**Addendum No. 2**

RE: Contract ID: C200840

Durham-Wake Counties (R-2904,U-4026)

NC-54 From SR-1999 in Durham County to SR-1959

CLEARING AND GRUBBING EROSION CONTROL FOR CONSTRUCTION SHEET 7

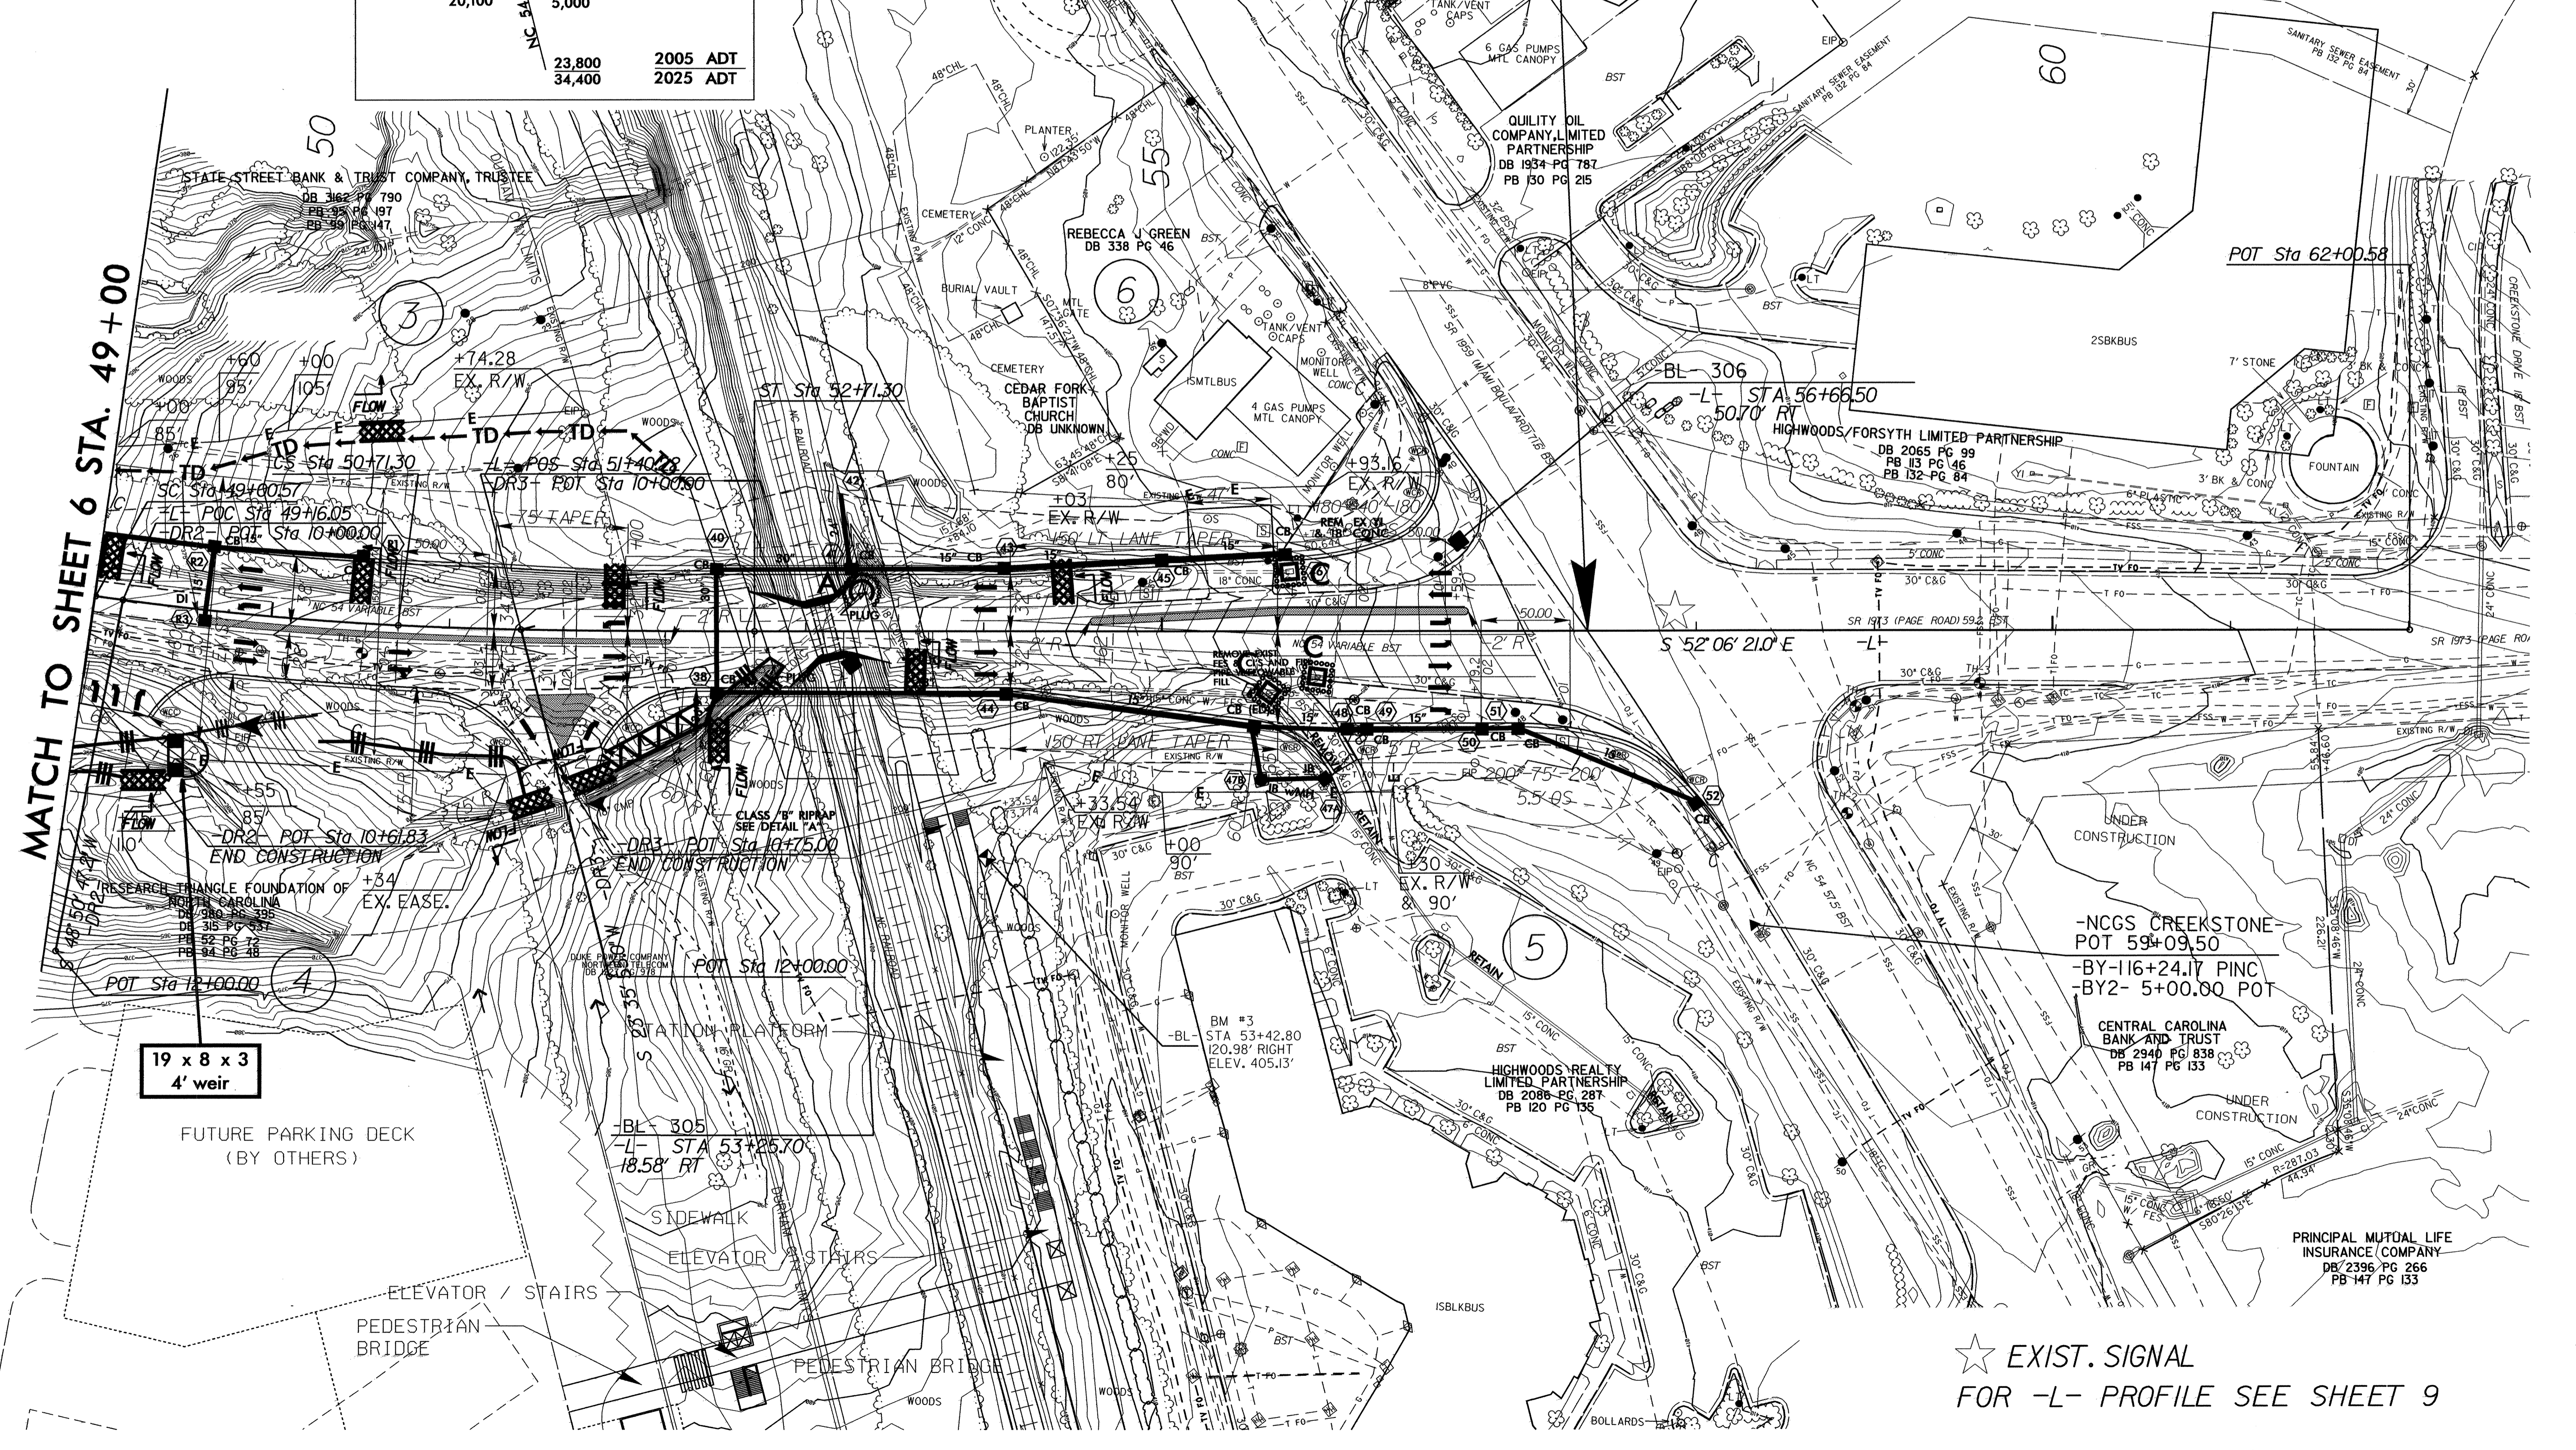
Please add the following note at the bottom of Sheet No. 7 of the R-2904 plans:

**“Blasting is not allowed on NCRP Property.”**

The Contract will be prepared with this note included on Sheet No. 7.
